KITTITAS COUNTY COMMUNITY DEVELOPMENT SERVICES

Subject: Shoreline Exemption Permit (SX-19-00003) - Request for Additional Information

SITE PLAN
 1/16" = 1'-0"
 1" = 16'-0"
 Scale in feet

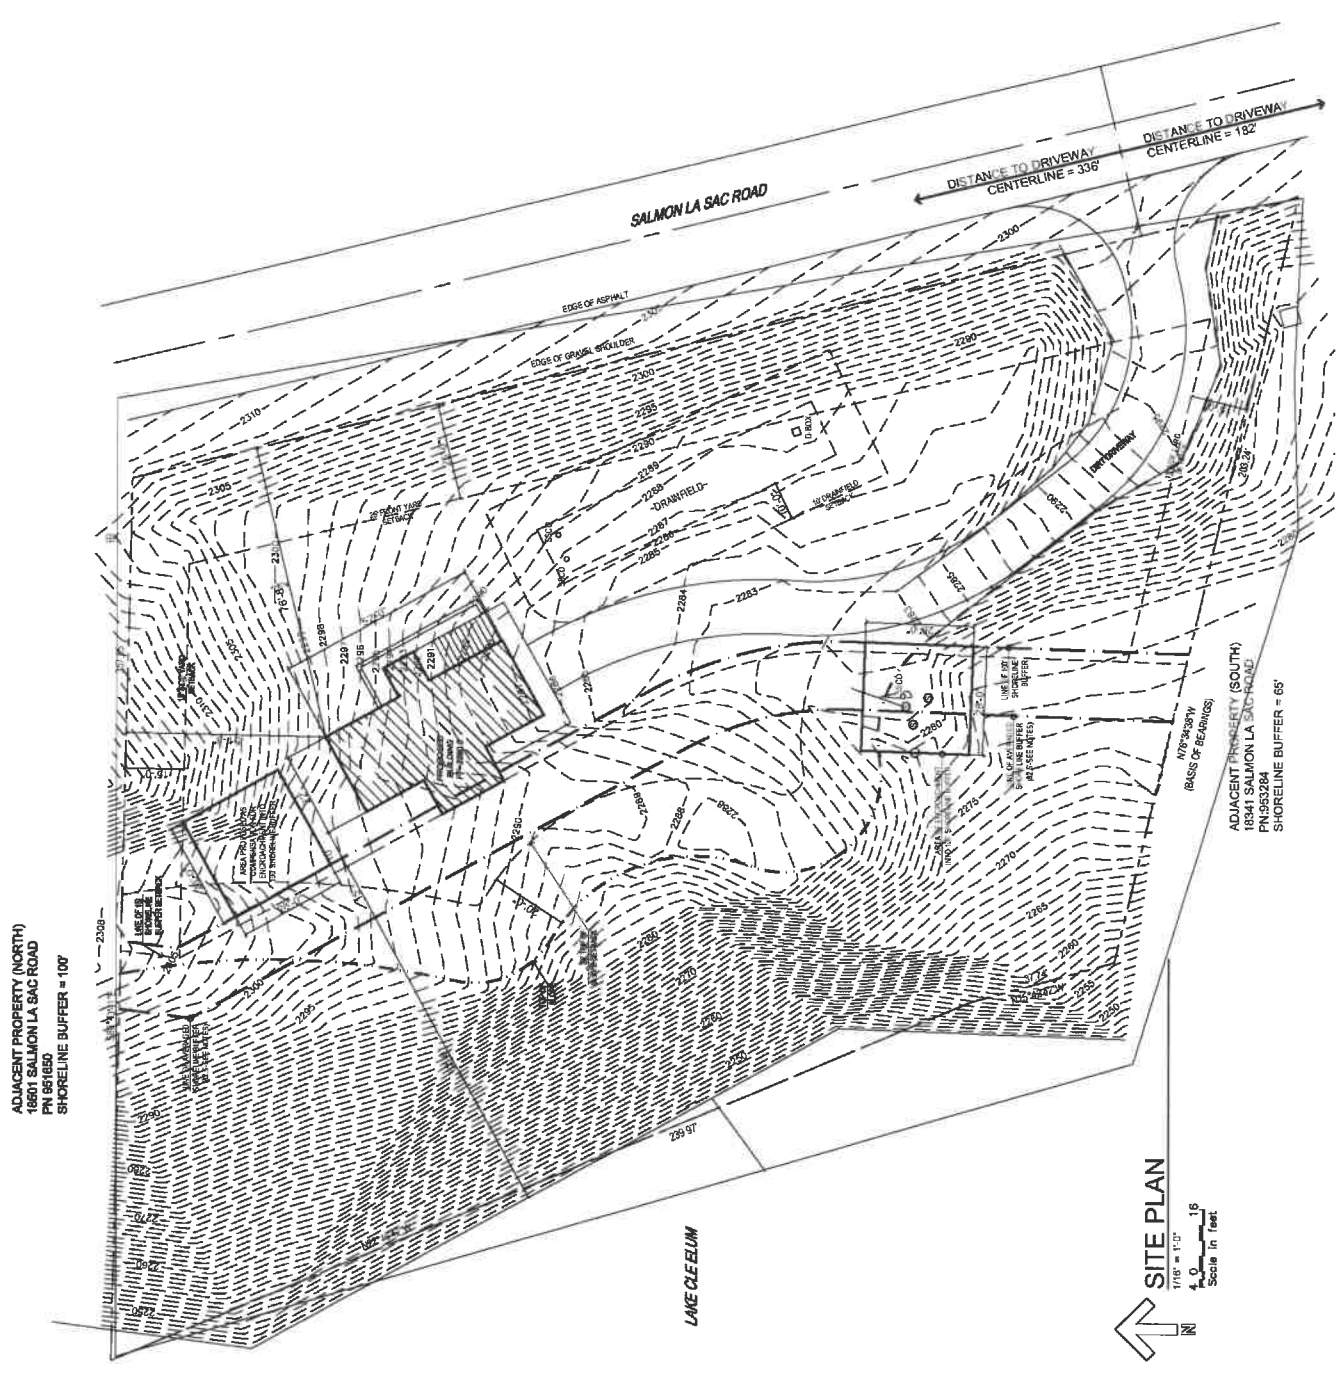
1. Updated site plan: there are noticeable discrepancies with the relation between property lines, and topography shown on the provided site plan vs. aerial photos and the most recent survey of the property. The survey shows that the east property line lies east of the Salmon La Sac road easement, whereas your site plan suggest otherwise. Please see Attachment A and C for a visual explanation of discrepancies. Please update your site plan accordingly.
